Householder Proforma

Application Ref: 2022/0005

Address: 6 Sheffield Road, Oxspring, Sheffield,
S36 8YQ

PROPOSED SIDE ELEVATION
SCALE 1:100

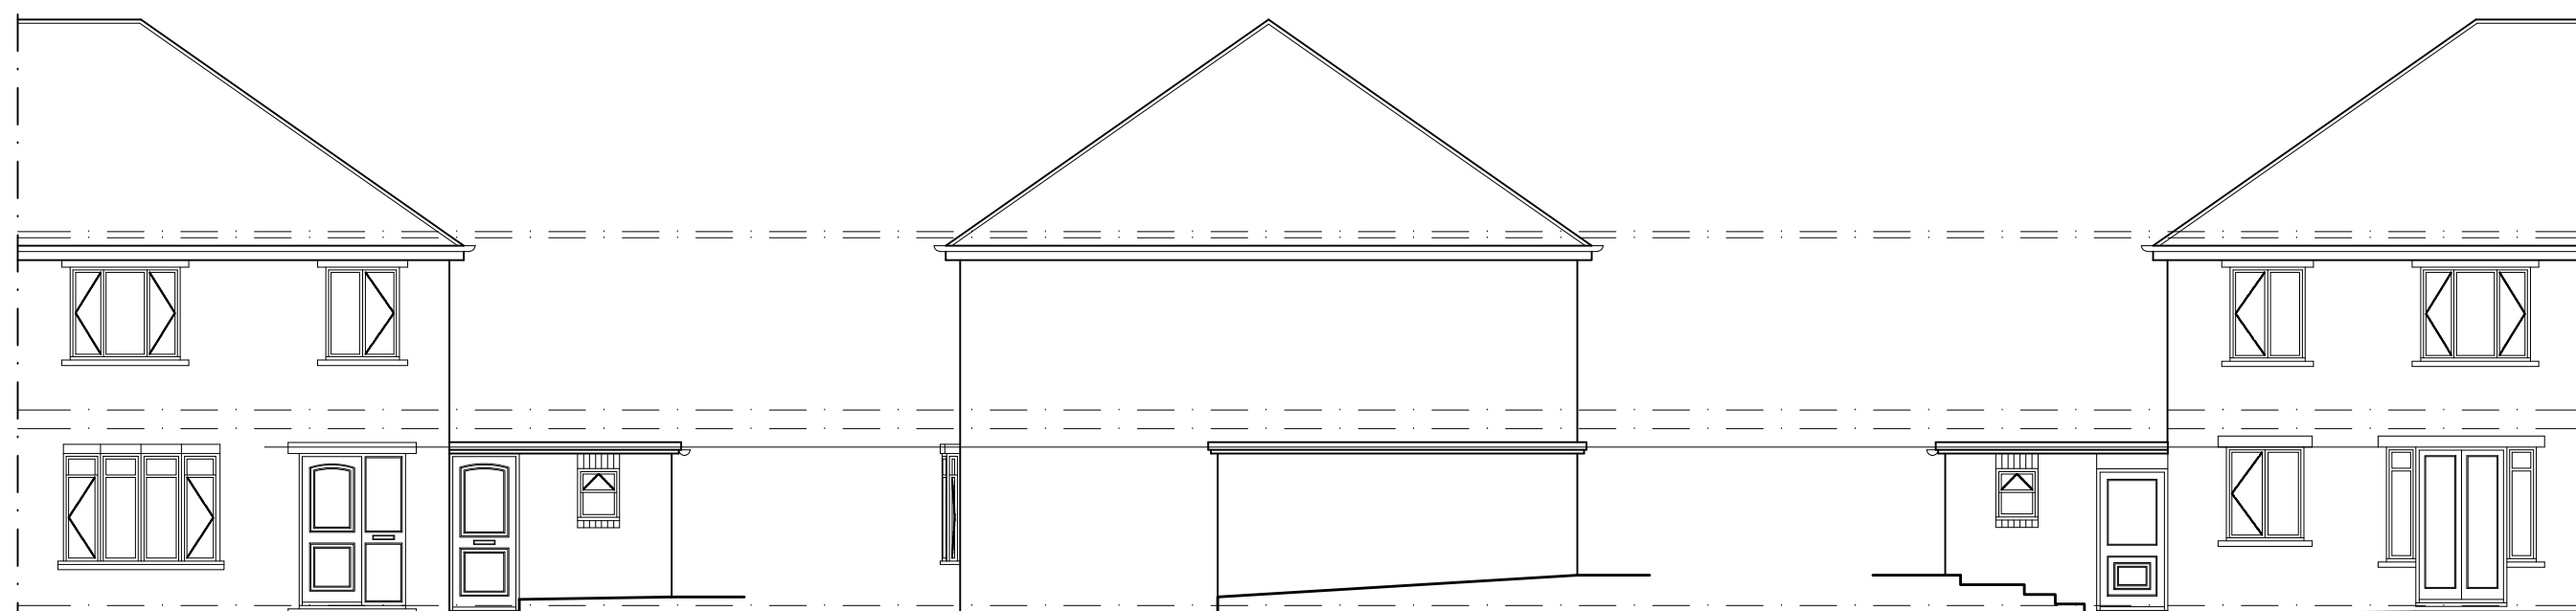
The proposed side/rear extension proposes a bi-folding door which faces the neighbouring stone built properties. Usual practice expects a distance of 21m between habitable room windows. In this instance the proposal is measured slightly under 21m, however presently there is screening via shrubs and a low stone wall, along with a driveway, and lane separating the properties. Furthermore, the host property is angled slightly therefore direct overlooking should not occur in this instance.

4. roof design corresponds to existing	Yes
5. windows / doors of a similar design / proportion	Yes
6. habitable room windows on the side elevation	Yes the bi-folding doors are located on the side elevation which faces the front of the neighbouring stone built properties. A distance of just below 21m is provided which is less than expected, however there is a large garden, road and driveway in-between the 2 properties along with the existing boundary. Due to the positioning of the proposal, it is not expected to compromise neighbouring privacy.

PROPOSED GROUND FLOOR PLAN
SCALE 1:50

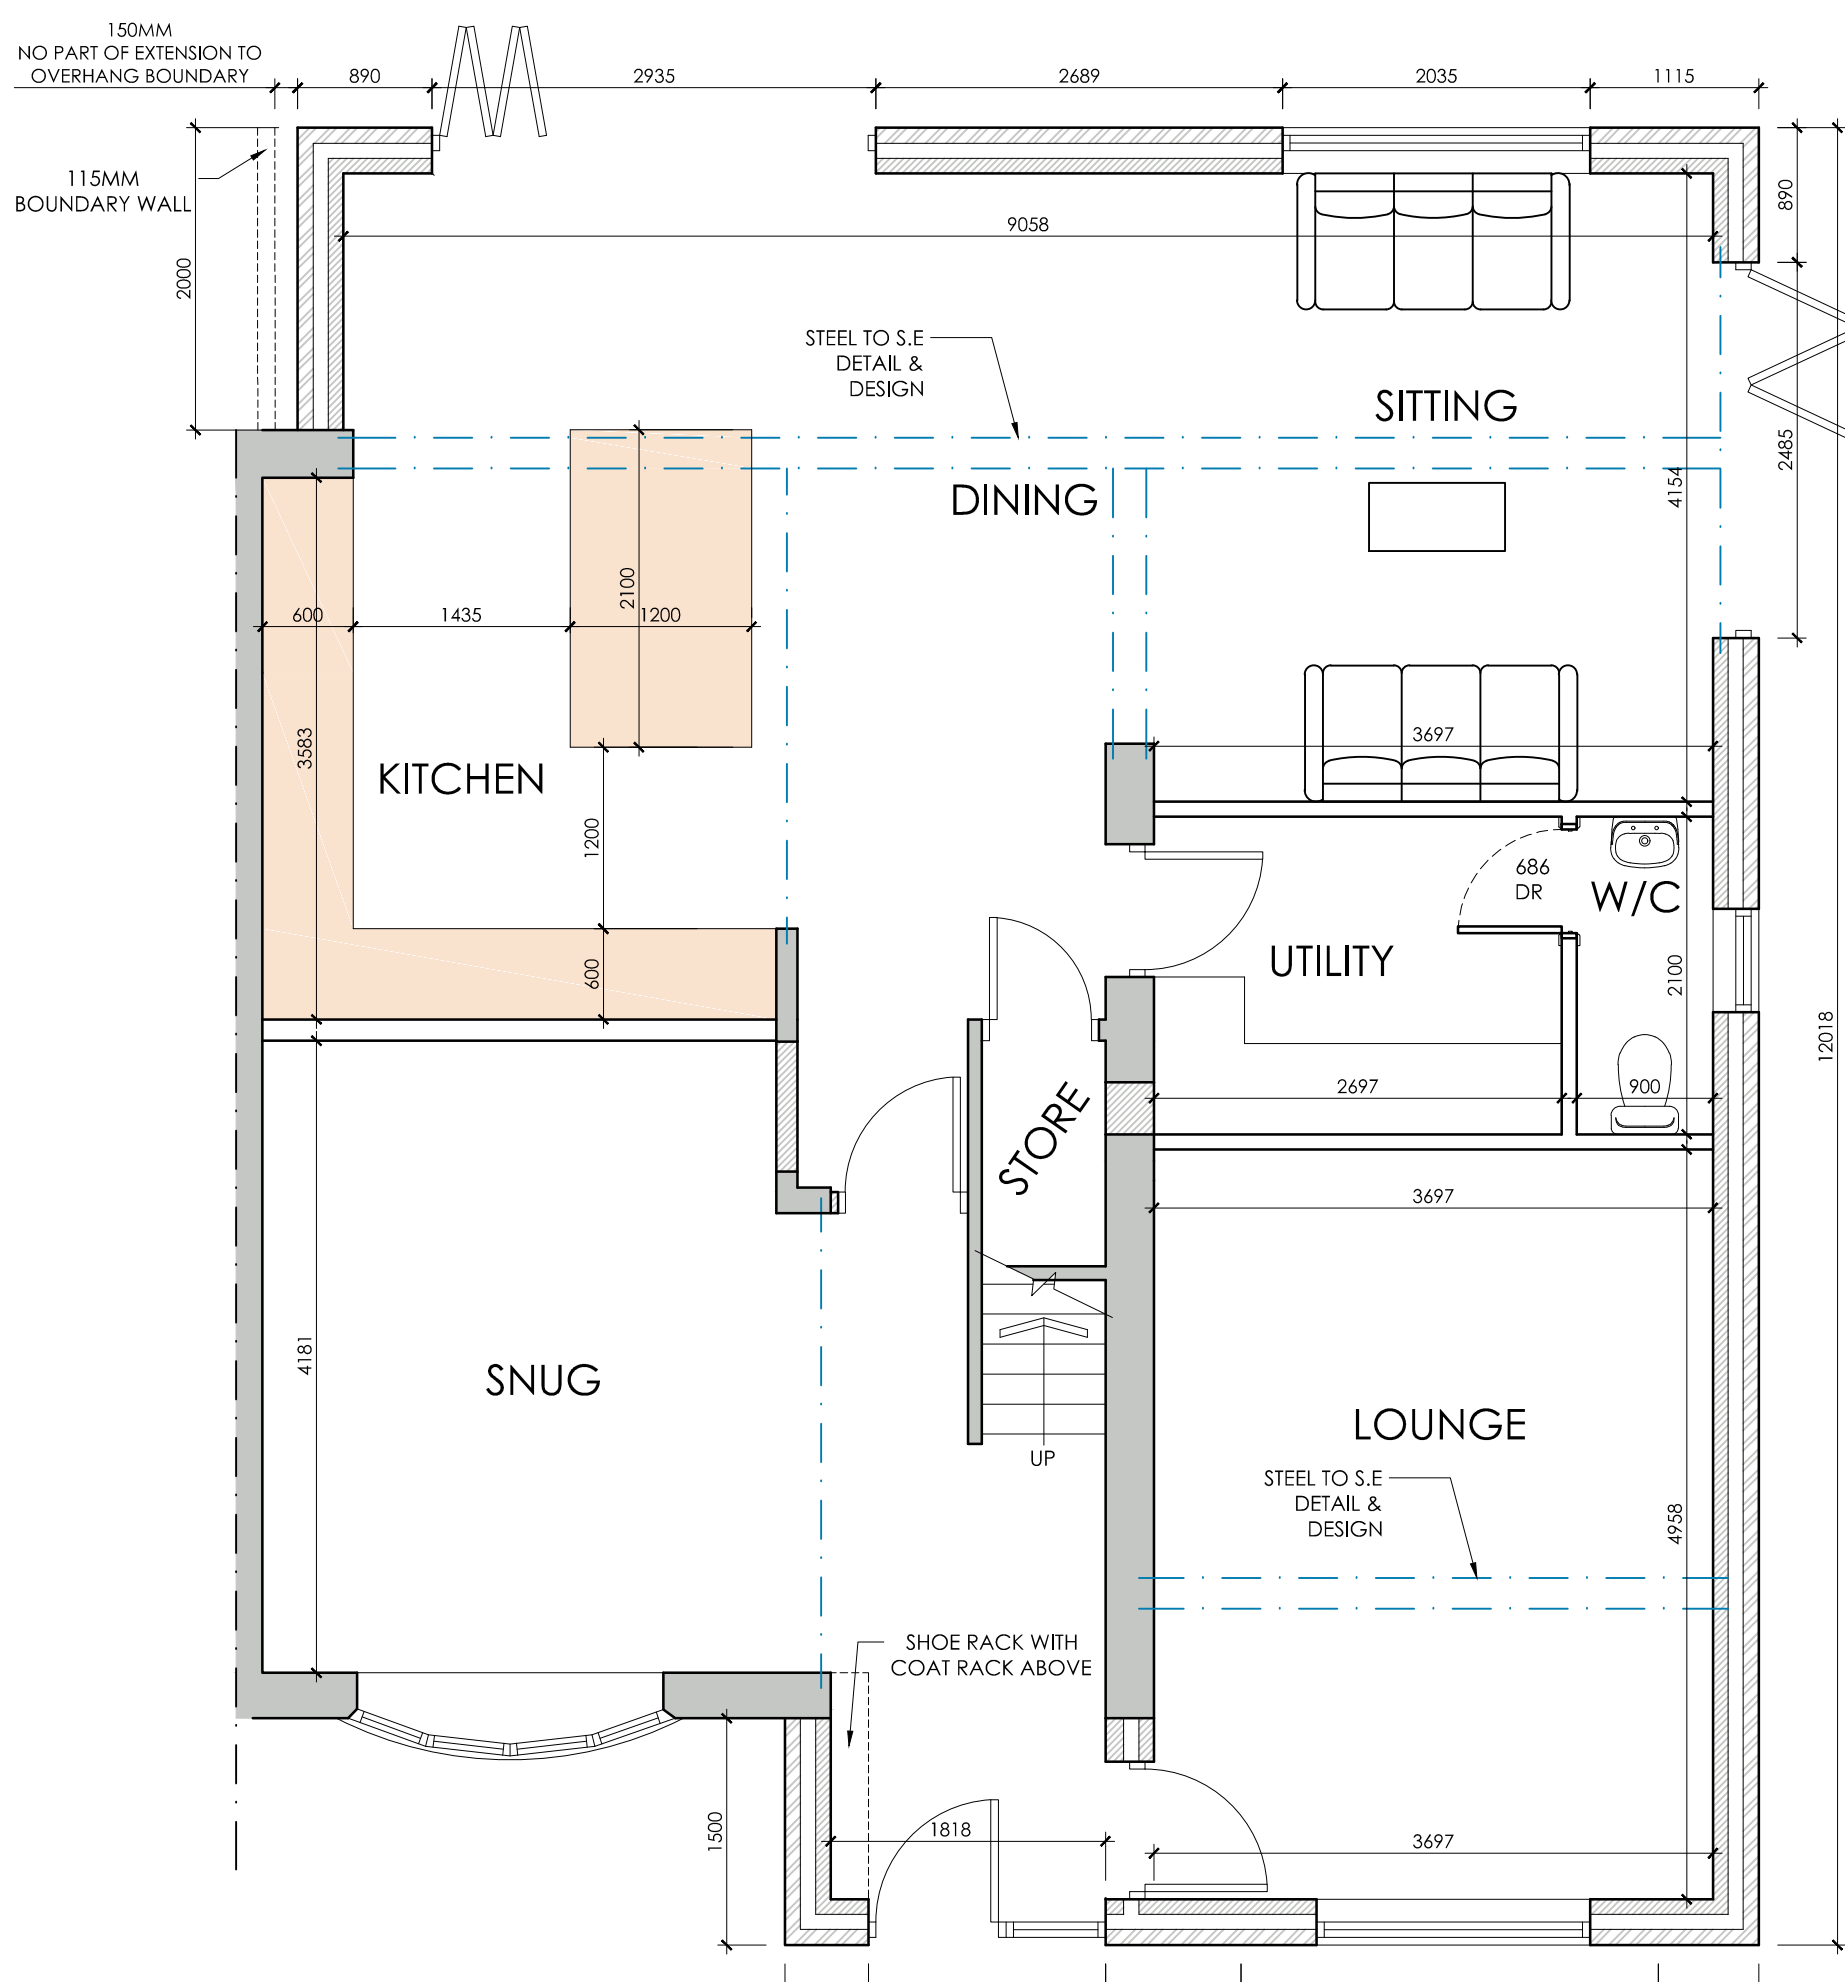
Proposed: The proposal is for a 2-storey side extension to replace the existing, a single storey front extension extending the side element forward and incorporating a porch and a single storey rear extension. The ground floor will comprise a porch, lounge, utility and open plan kitchen-diner and sitting room. The upper floor will provide a bedroom with en-suite. The side extension will project to the side by 4m with a set back of 0.675m at first floor level with a corresponding lowered roof line. The front extension will project 1.50m, single storey with a lean to roof and the rear extension will project 2m single storey with bi-folding doors to the rear and bi-folding doors on the side elevation encompassing the new and old build.

2. semi-detached and less than 4m?	Yes
3. if more than 3m are the eaves more than 2.5m in height?	2m projecton
Two Storey	
4. terraced property and less than 2.5m (projection to the rear)?	
5. semi-detached and less than 3.5m?	
All	
6. materials to match	Yes
7. roof design compliments / ties in well	Yes lean to
8. habitable room windows on the side elevation?	Yes the bi-folding doors as stated above.
9. distance to rear boundary (shared with another residential property) 10m or more?	No, however the proposed rear extension is single storey and there is an existing boundary hedge providing adequate screening.

Yes
1. single storey?	Yes
2. small projection? (confirm measurement)	Yes 1.5m
3. roof design corresponds to existing	Yes lean to as per rear extension
4. windows / doors of a similar design / proportion	Yes
5. materials to match	Yes
